**KIRKLEES METROPOLITAN COUNCIL
INVESTMENT & REGENERATION SERVICE**

Reference No:	2025/62/90986/E
Site Address:	5, Raikes Wood Drive, East Bierley, BD4 6RE
Description:	Demolition of existing side extension and erection of single storey side extension and rear alterations
Recommending Officer:	Faiza Bano

HOUSEHOLDER DELEGATED REPORT

Title -  
PROPOSED GROUND FLOOR PLAN

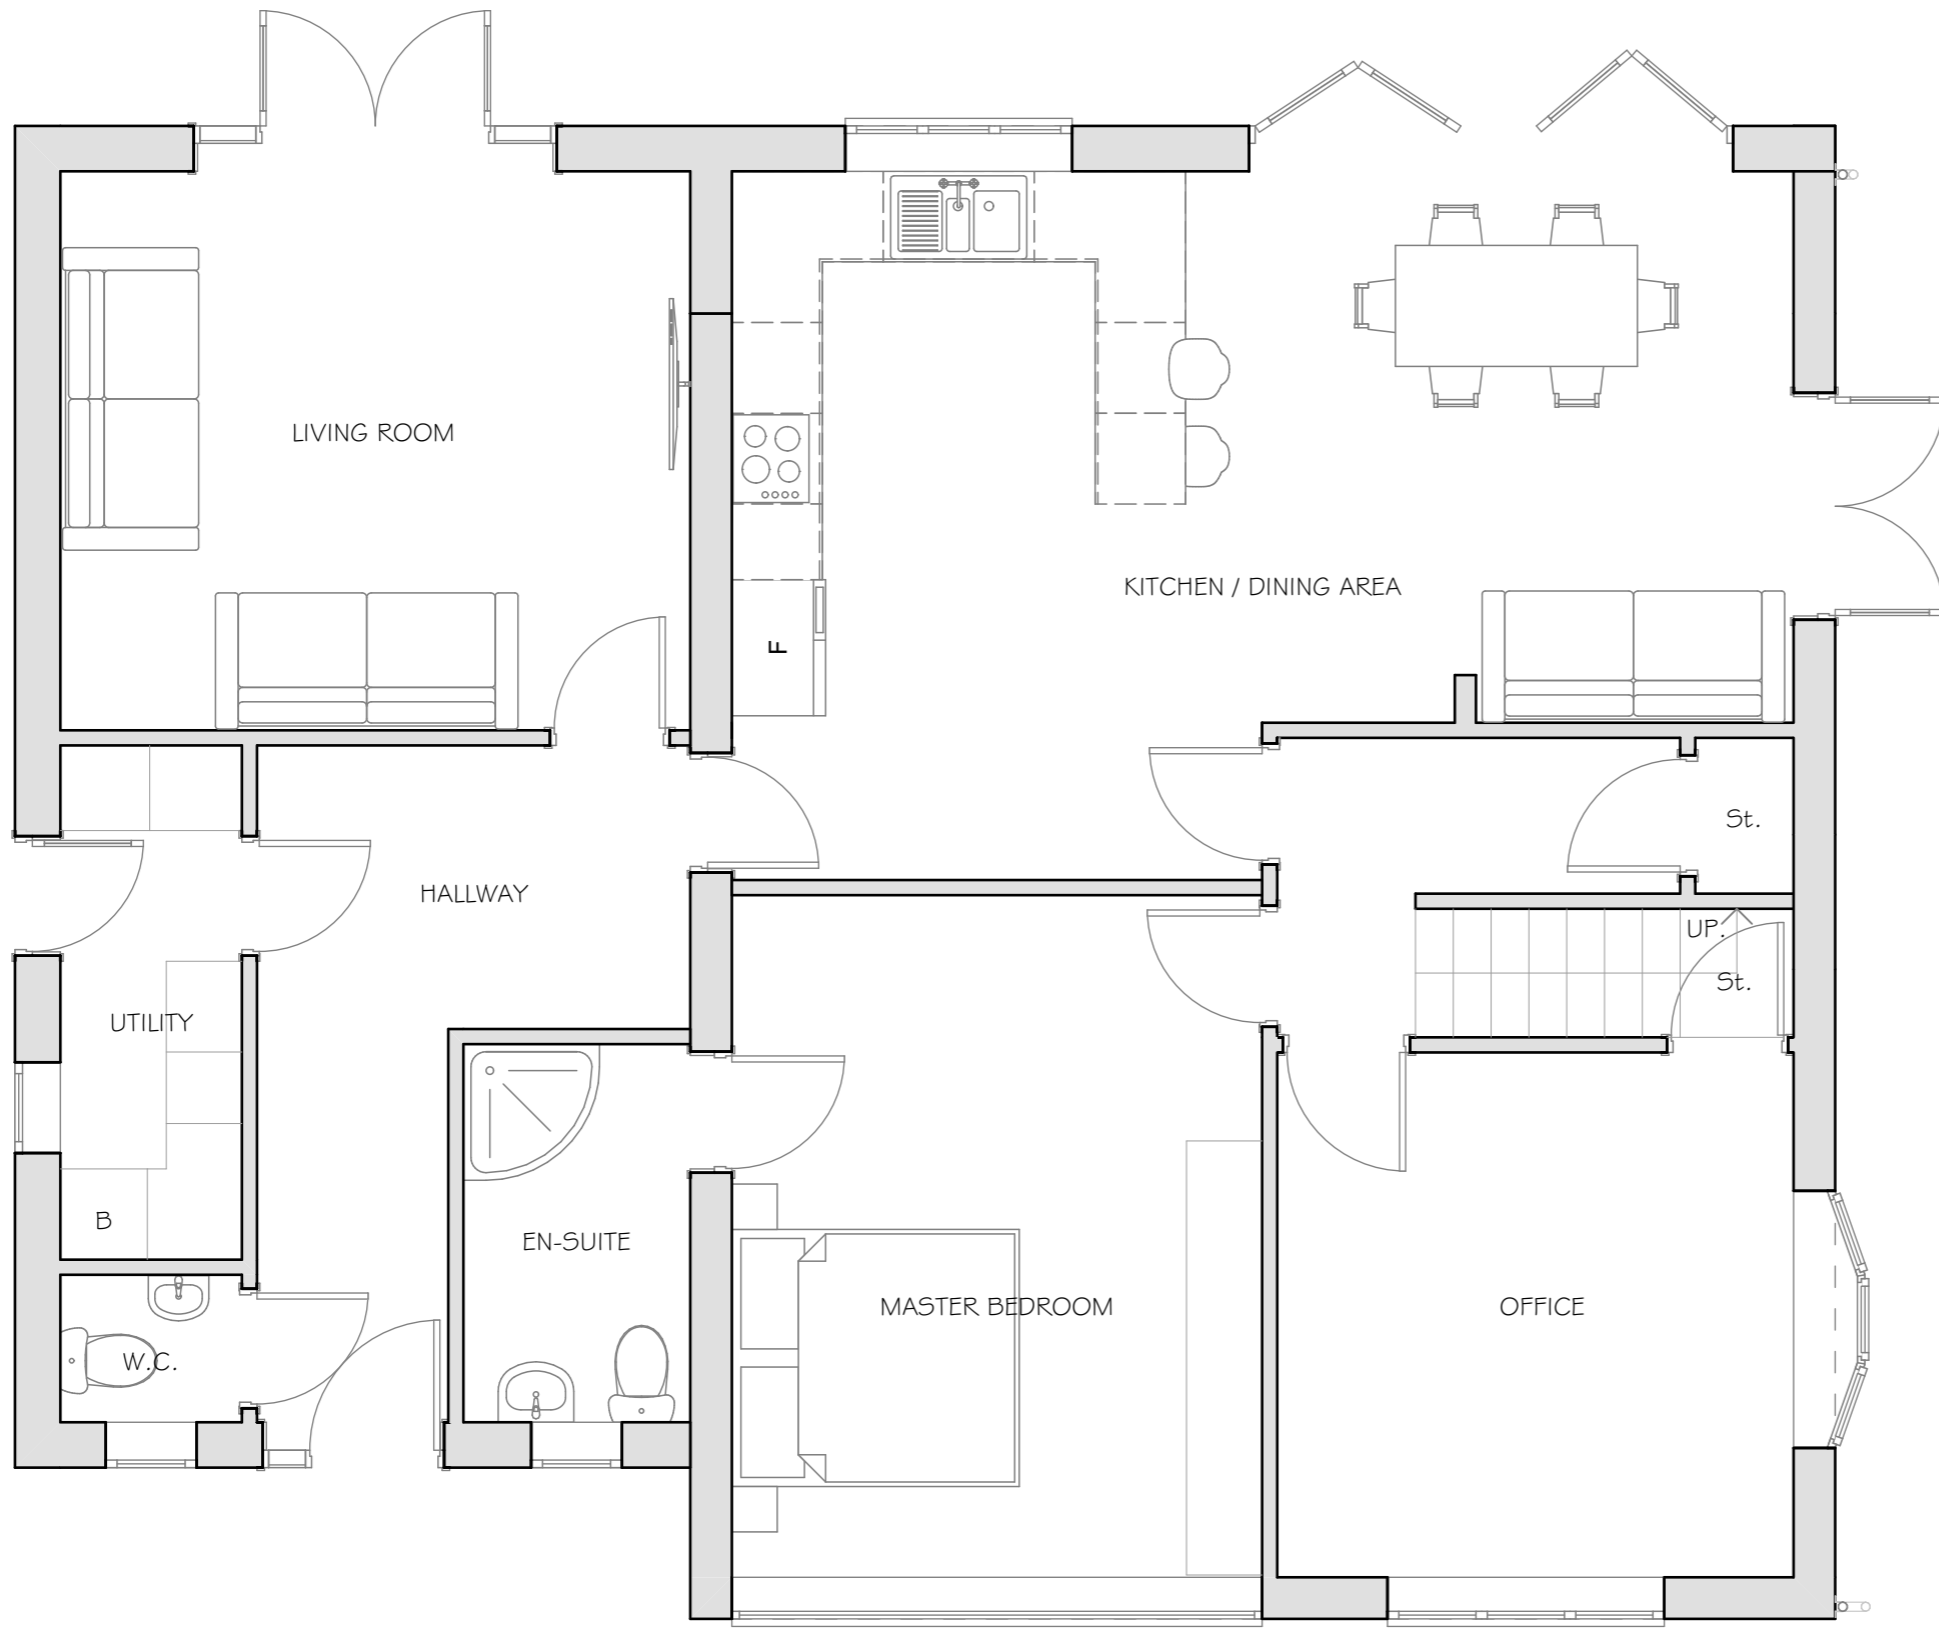
Single storey side extensions should be offset and complement the original building. As such, single storey side extensions should:	<u>Yes - COMPLY</u>	<u>No - JUSTIFY</u>
not extend more than two thirds of the width of the original house;	Yes – the proposed extension projects out by 4.5m.	
not exceed a height of 4 metres; and	Yes - the height of the proposed extension is set below the height of the existing roof	
be set back at least 500mm from the original building line to allow for a visual break	Yes - the extension is set back by 1m

Title -
PROPOSED ELEVATIONS (2 of 2)

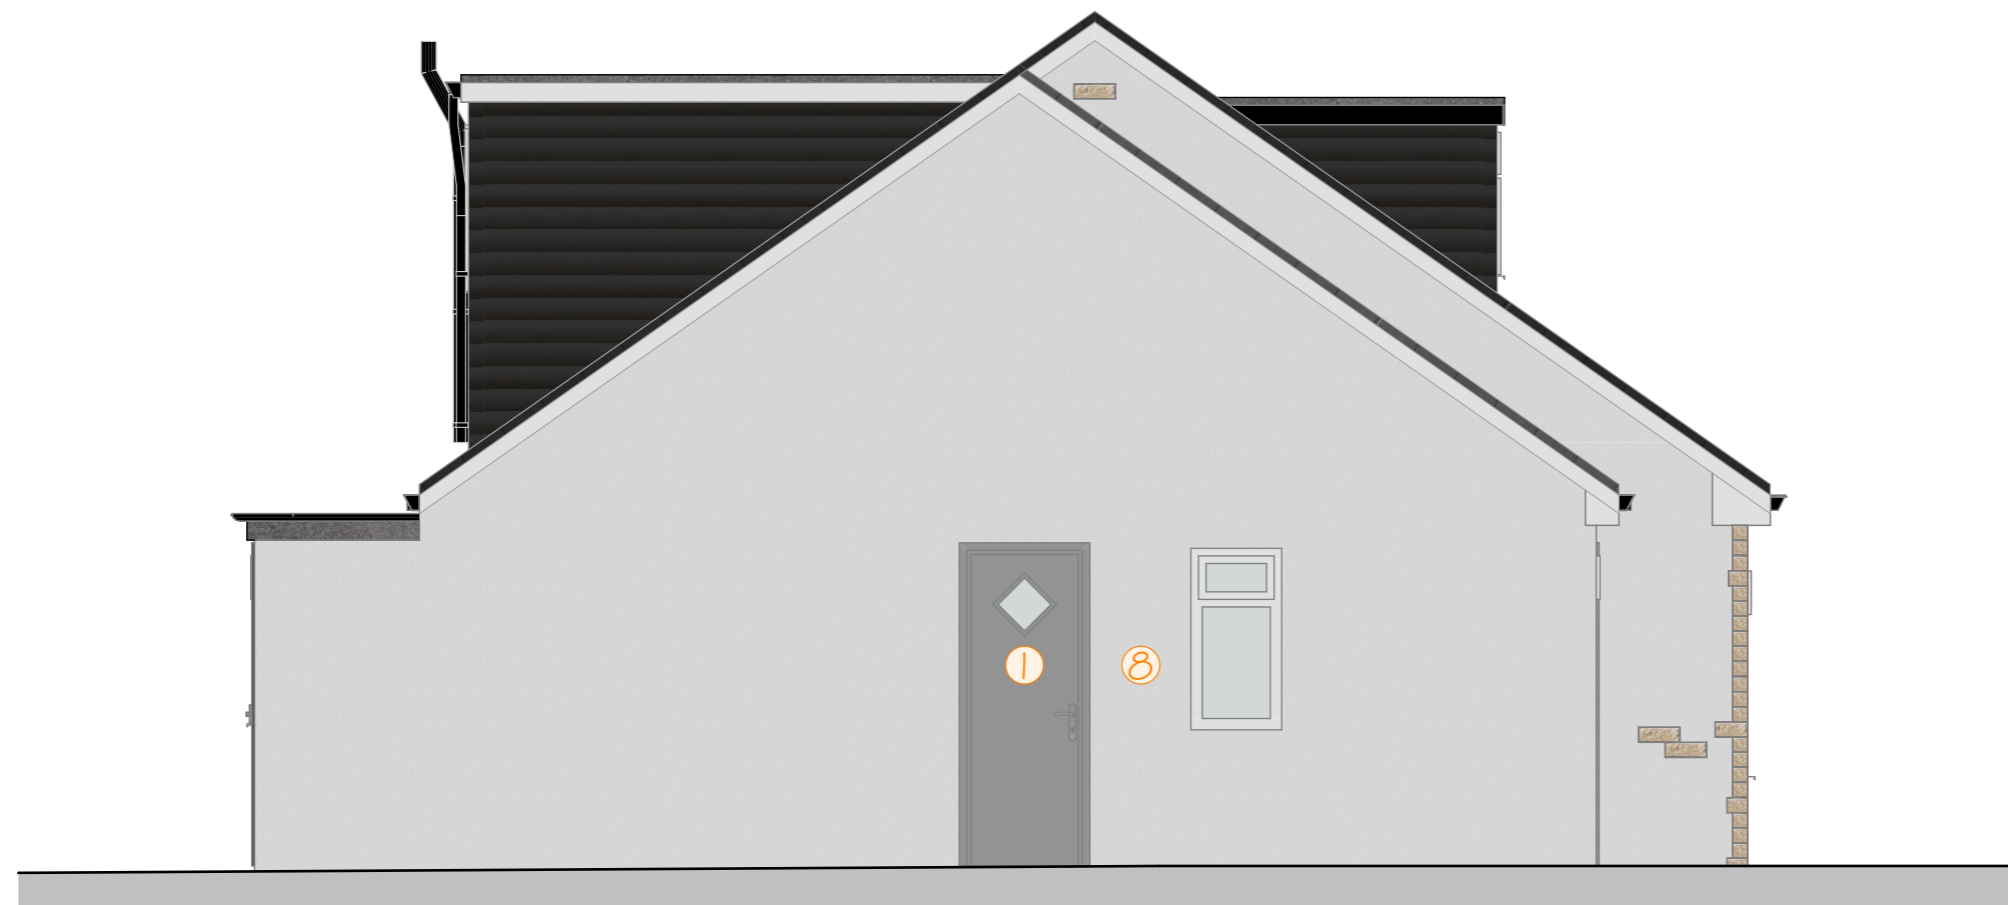
Facing materials and detailing	<ul style="list-style-type: none"> • KDP 9 of the SPD • Policy LP24 Design (d) (iii) of the KLP • Chapter 12 of the NPPF 	Facing and roofing materials, along with opening details to match existing.	✓

Roof style	<ul style="list-style-type: none"> • KDP 1 and 2 of the SPD • Policy LP24 Design (a), (c) and (d) of the KLP • Chapter 12 of the NPPF 	Pitched roof which matches the existing.	✓
Window proportions	<ul style="list-style-type: none"> • KDP 1 and 2 of the SPD • Policy LP24 Design (a), (c) and (d) of the KLP • Chapter 12 of the NPPF 	Proportions match the existing property.	✓
Accessibility for all users	<ul style="list-style-type: none"> • KDP 17 of the SPD • Policy LP24 Design (f) • Chapter 12 of the NPPF 	Private domestic extension which would not change the existing access into / around the property	✓

3. The external walls and roofing materials of the extension hereby approved shall in all respects match those used in the construction of the existing building.
